**Application Reference:** 6/2023/1354/COND

**Proposed development at:** 71 Station Road Cuffley EN6 4HG

**Proposal:** Submission of details pursuant to conditions 1 (Contamination), 2 (Footway crossovers and dropped kerbs), 3 (Construction Management Plan), 4 (Drainage), 5 (Materials), 6 (Fence height), 7 (Noise Impact), 8a (Accessible and adaptable housing), 9 (Biodiversity), 10 (Energy and sustainability), 11 (Cycle provision, refuse and recycling), 16 (External lighting), 17 (Bollards for car parking) and 20 (Parking allocation) on planning permission 6/2021/0456/MAJ

ORIG	S.E.C	DATE	02.02.21
CHKD		SCALE	1:100@A1
APPR		DRAWING NO	2592-05
		REV	A

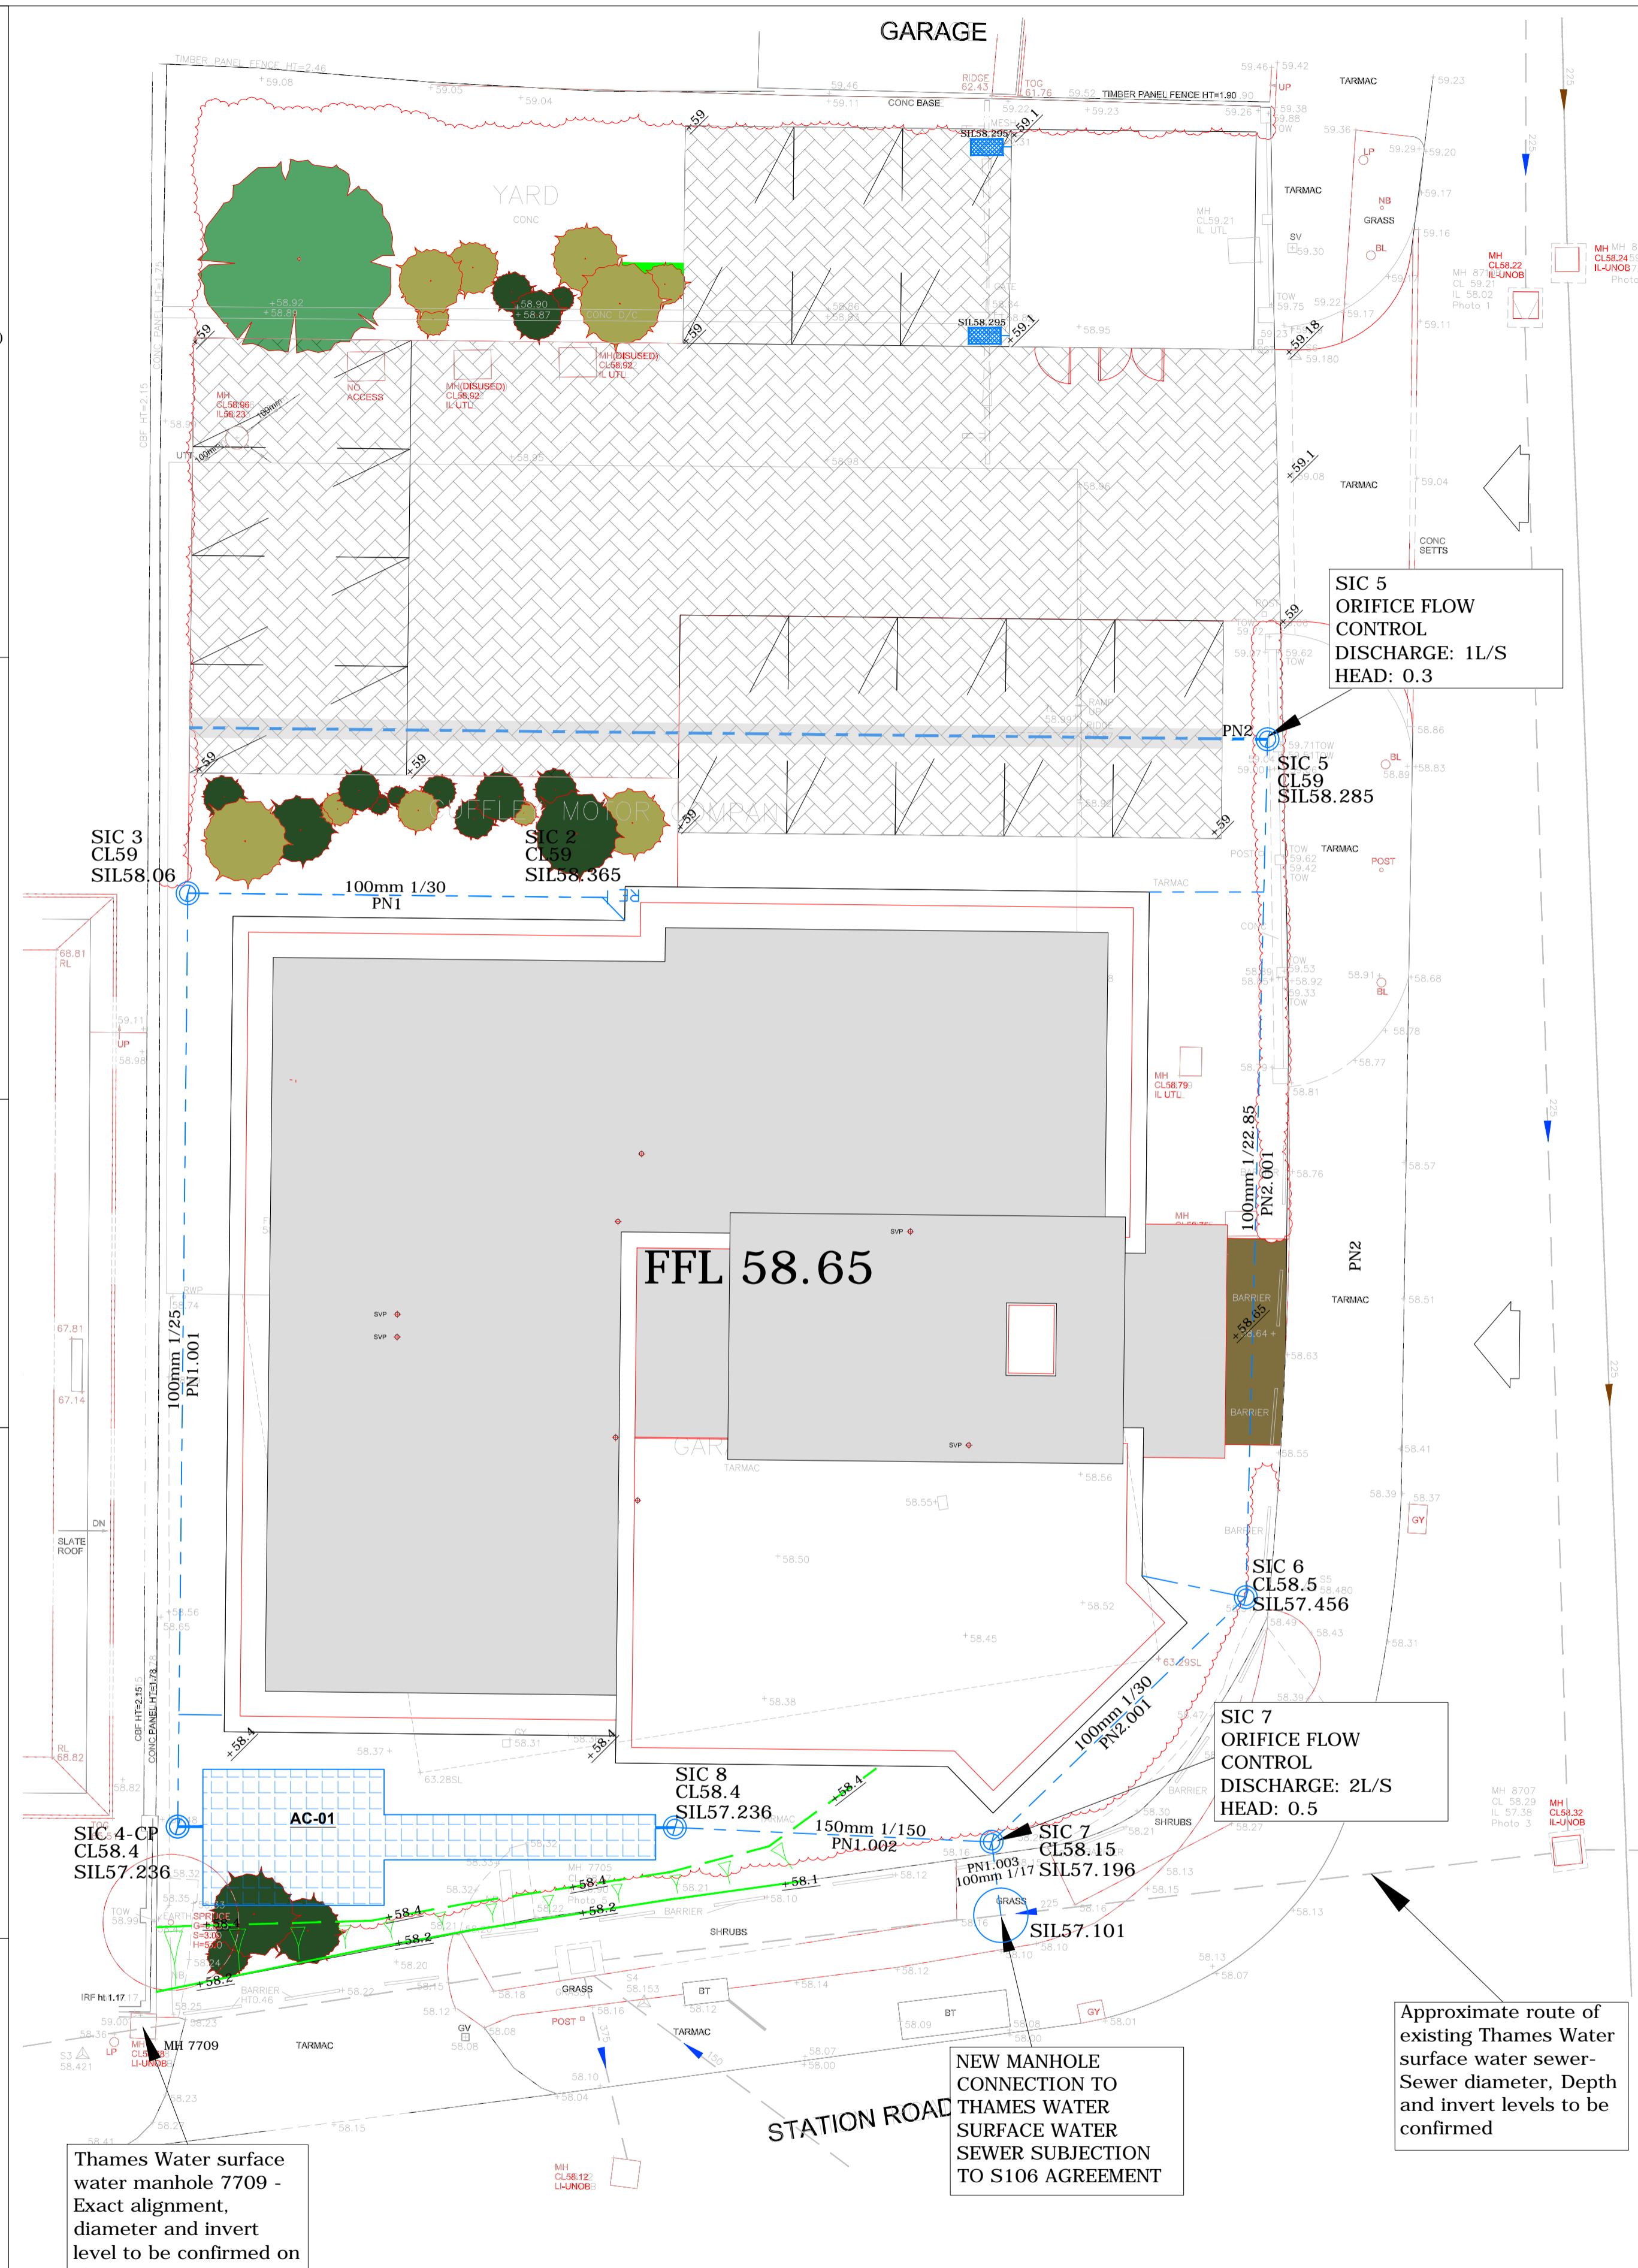
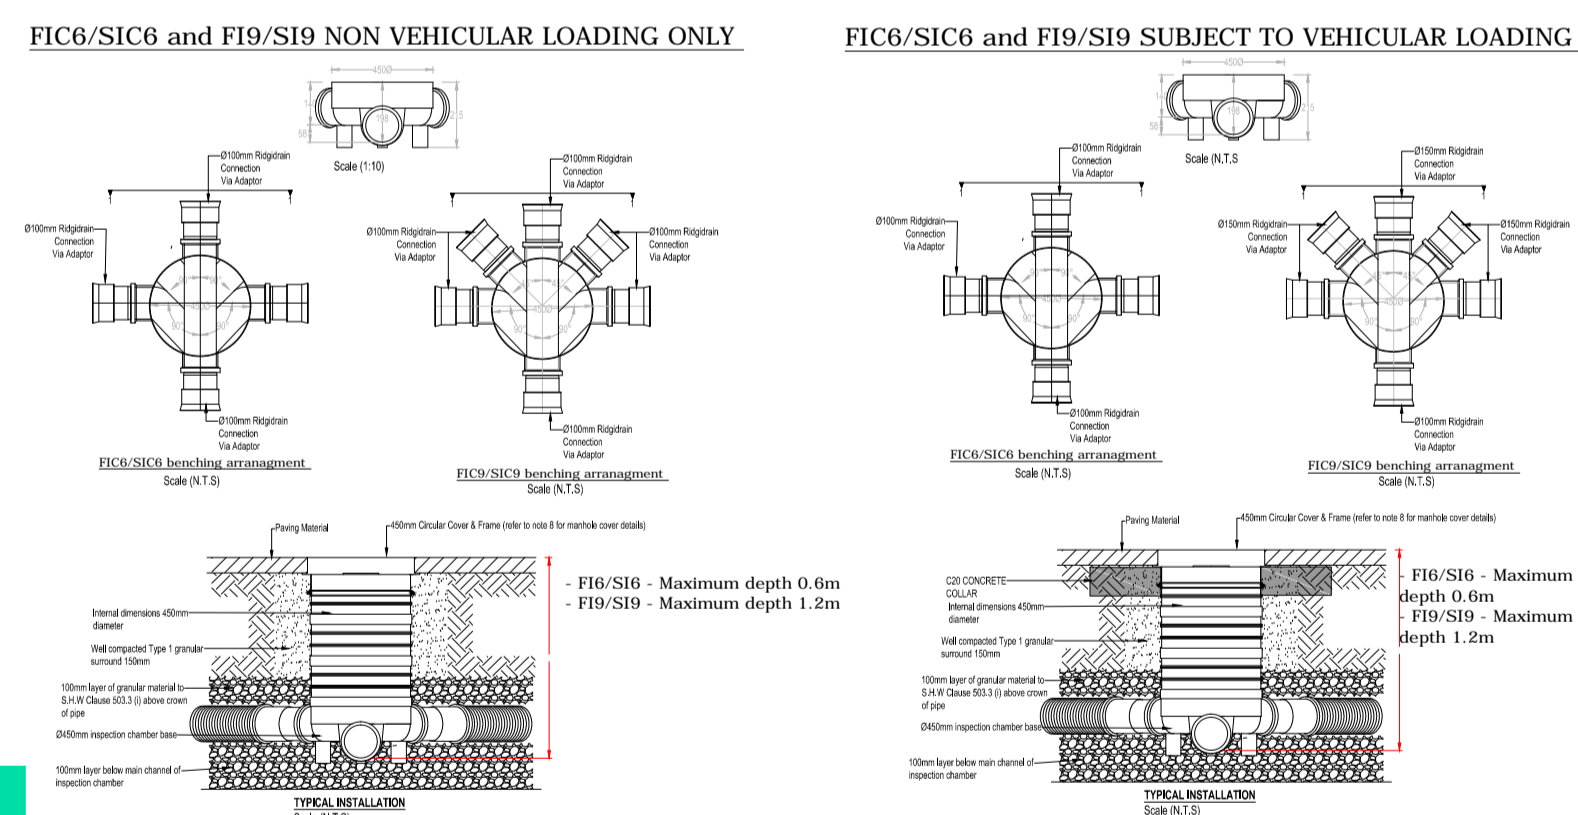
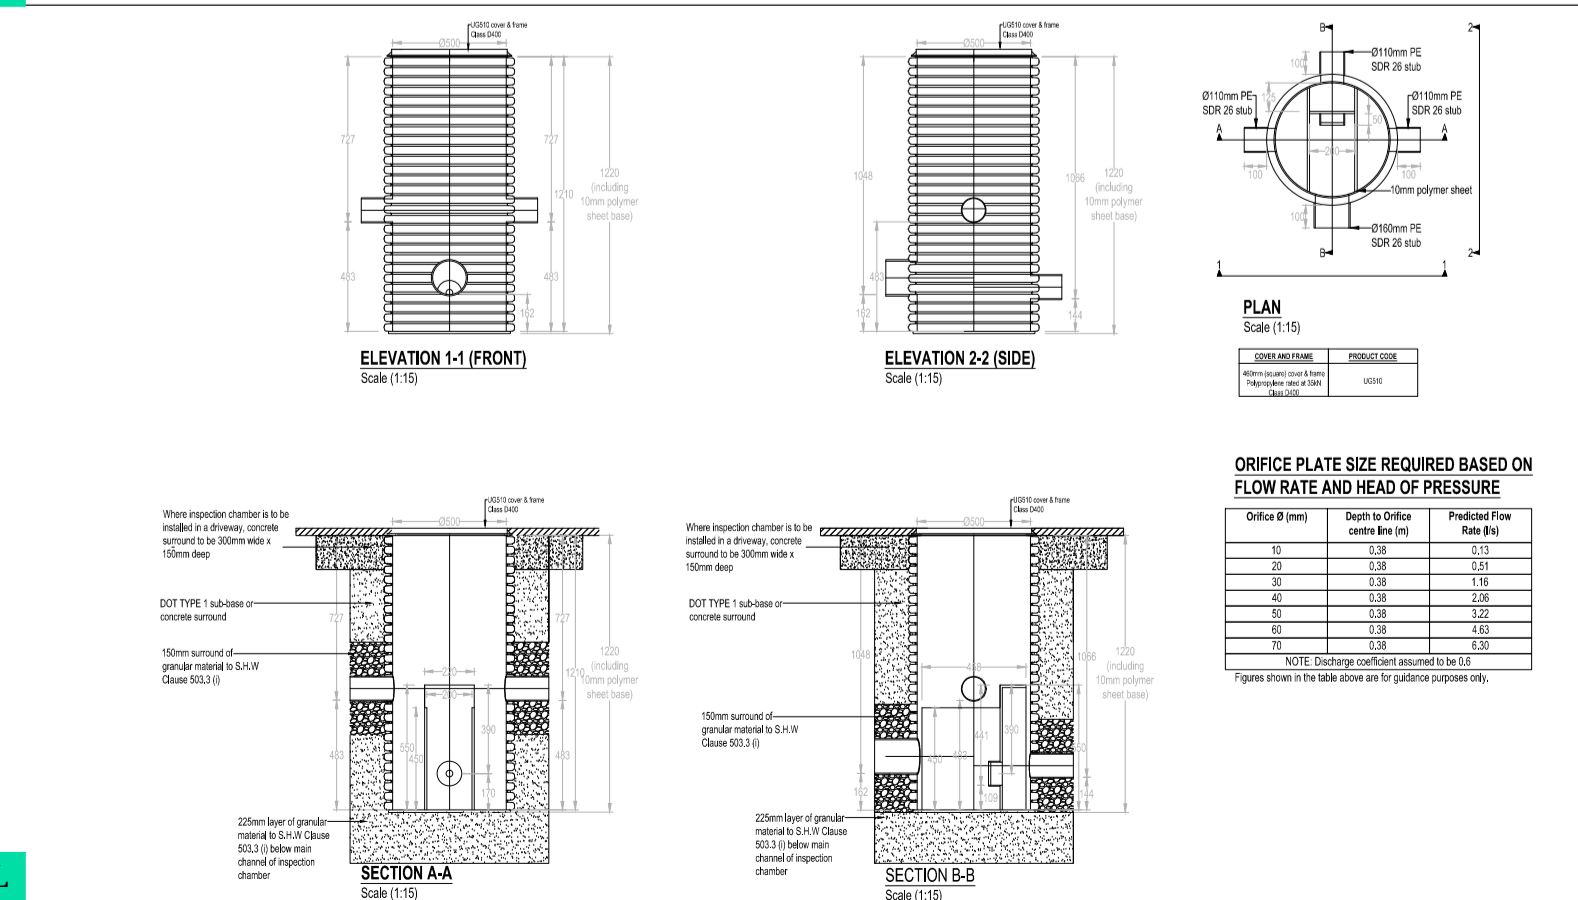
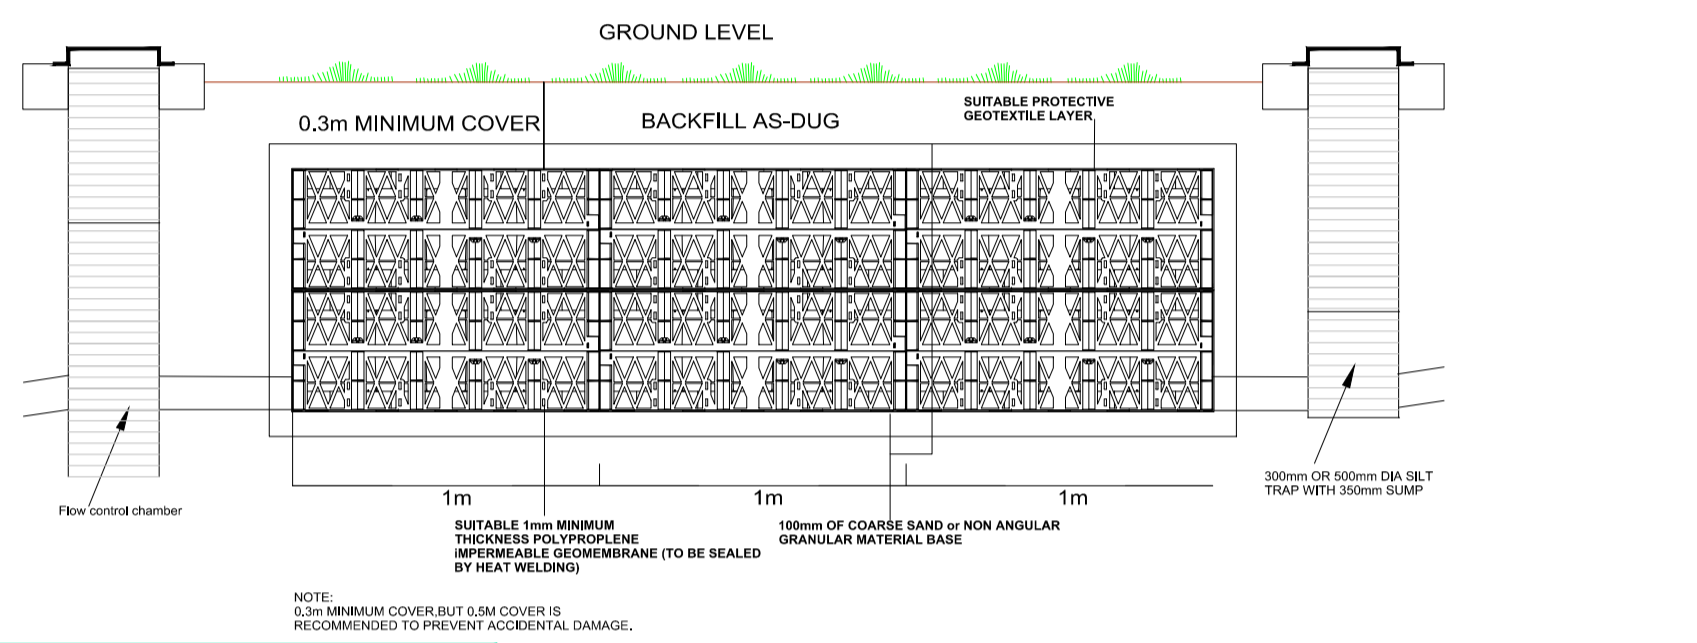
- Micro Drainage Calculations dated 20 June 2022
- Indicative Drainage Plan (drawing number: 2592-05 Rev A)

As development has commenced, this condition cannot be discharged. The details submitted would have been deemed insufficient for the reasons set out in the consultation response from the Lead Local Flood Authority, dated 14 July 2023.
